Cherwell District Council
Development & Property Services
Bodicote House White Post Road
Bodicote
Banbury
OX15 4AA

Our ref: WA/2015/120747/02-L01
Your ref: 15/00839/REM
Date: 04 September 2015

**Amended plans - reserved matters to 05/01337/OUT - 125 residential units on parcels D and E
Longford Park, Parcel D And E, Phase 3, Longford Park Road, Bodicote**

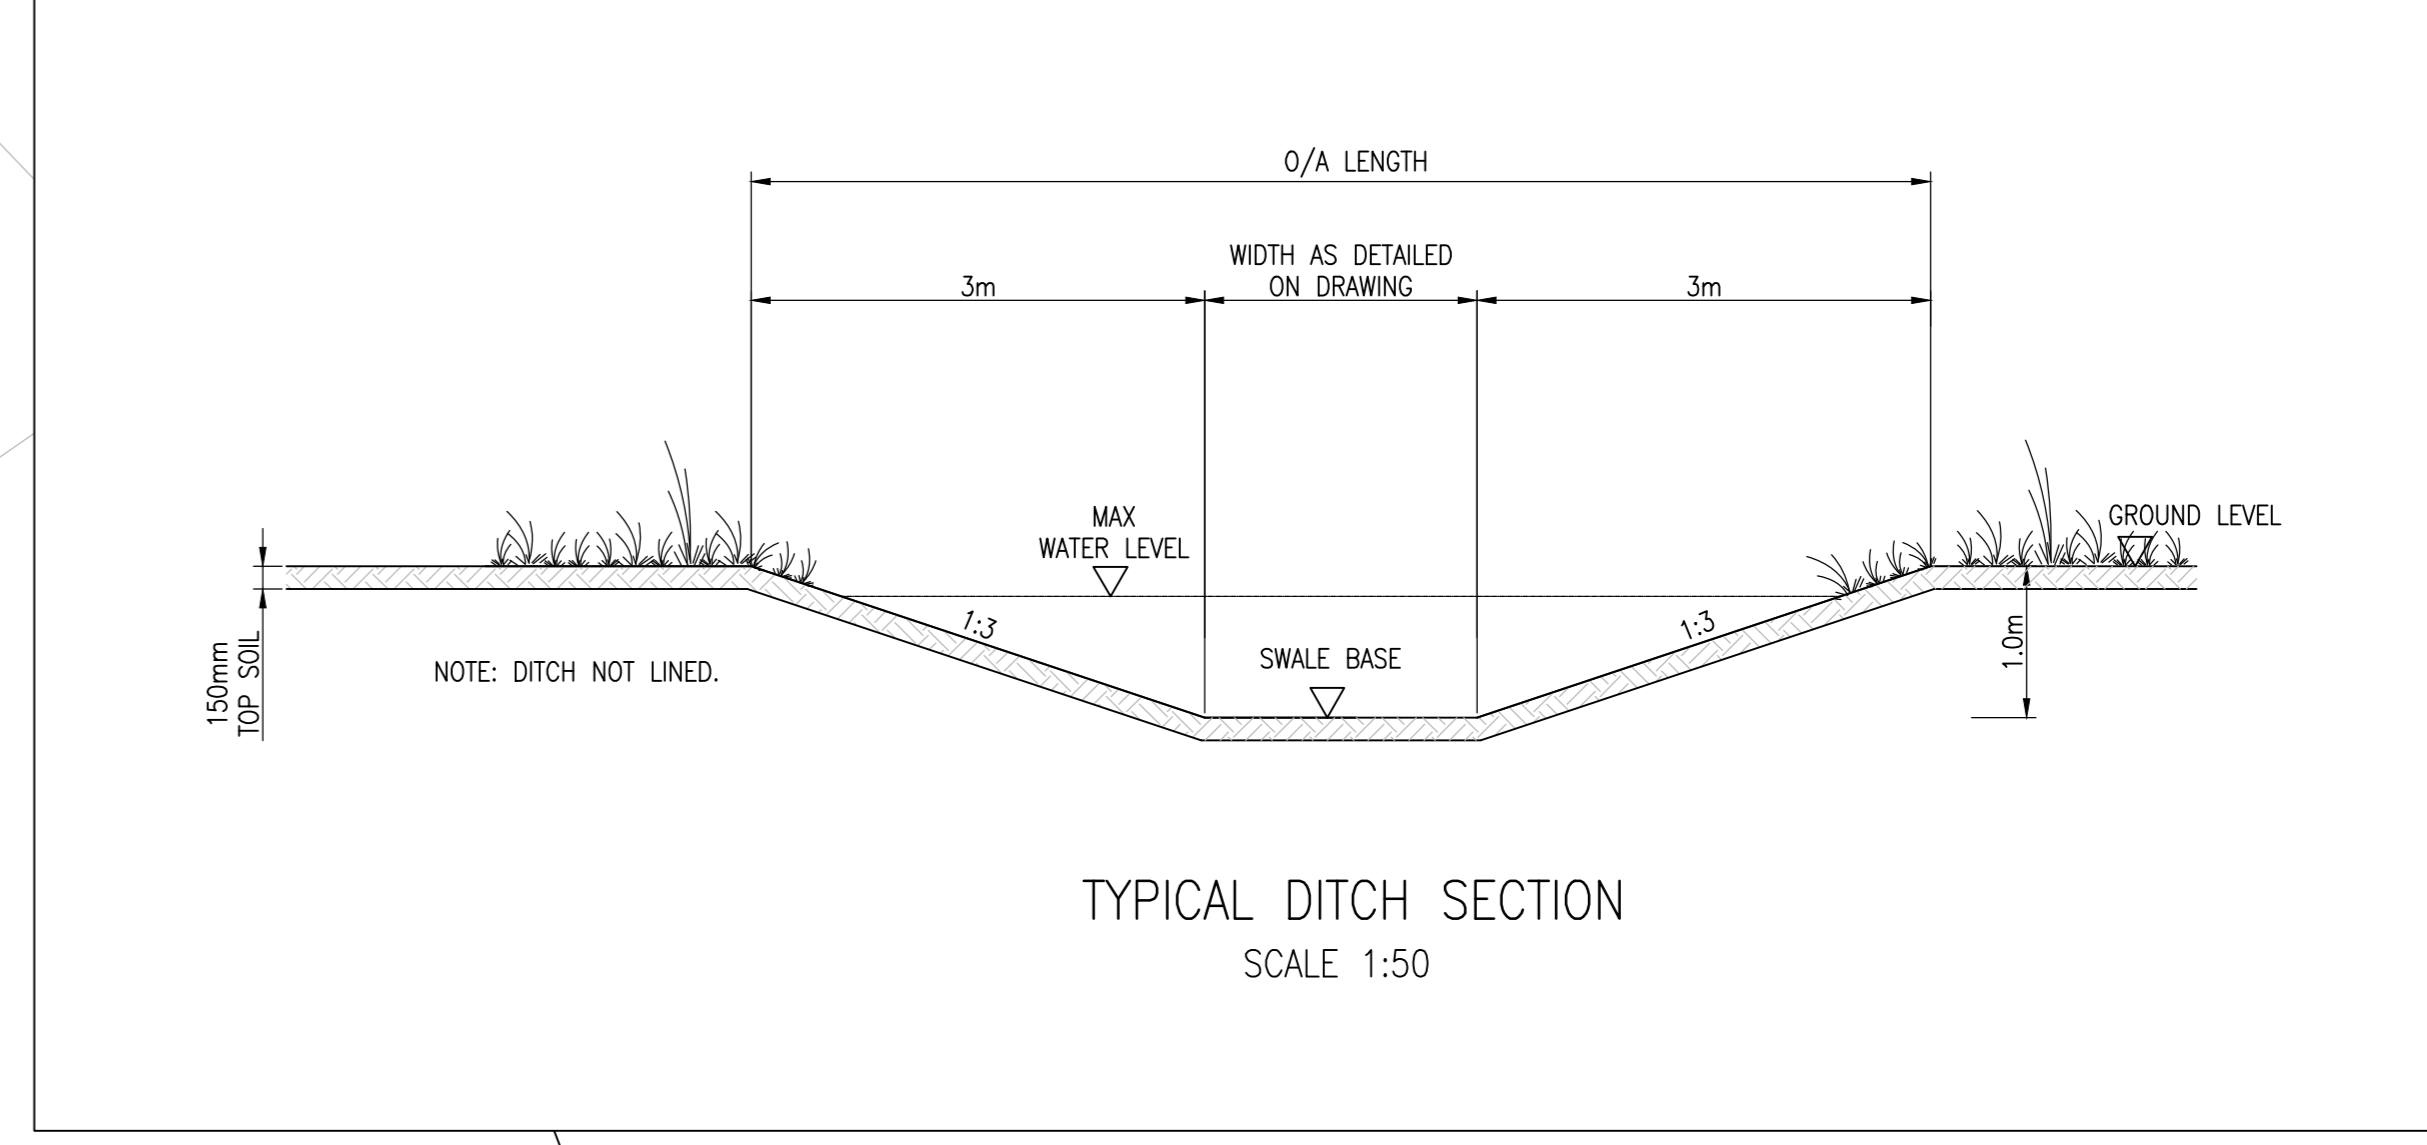
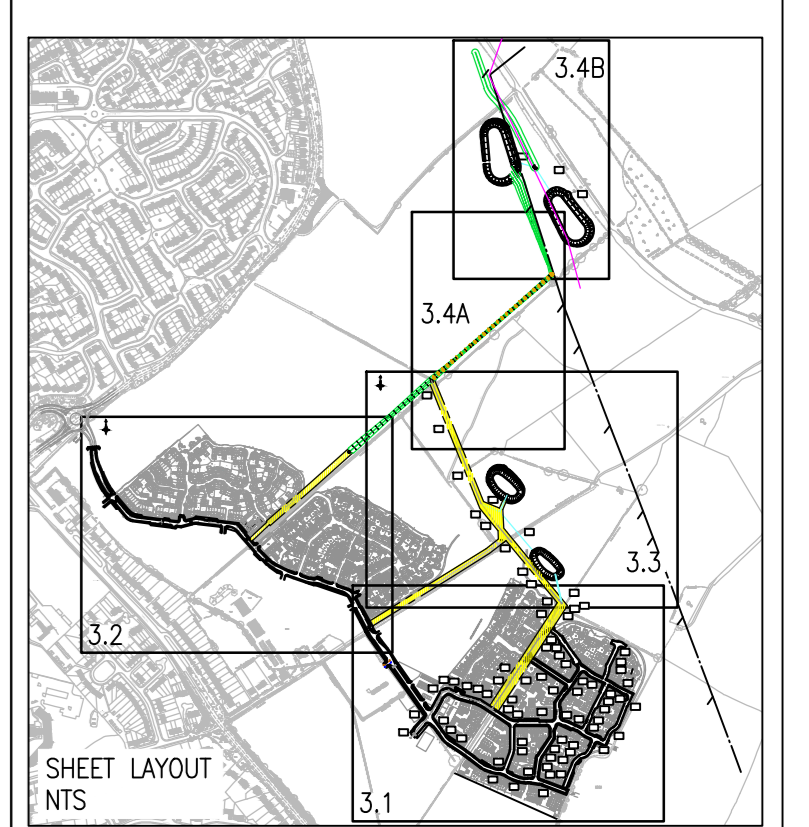
We have reviewed sheets 1, 2 and 3 of the manually revised M-EC drawing numbers 20488_02_070_10.2, 20488_02_070_10.3 and 20488_02_070_10.4 respectively, all dated 12/09/2014 but registered on the Local Authority website as AMD 19/8/15 Parcel 2.

The pen marked route demonstrates how the drainage from phase 3 fits in with the overall site strategy.

We are therefore in a position to **remove our objection** on this reserved matters application.
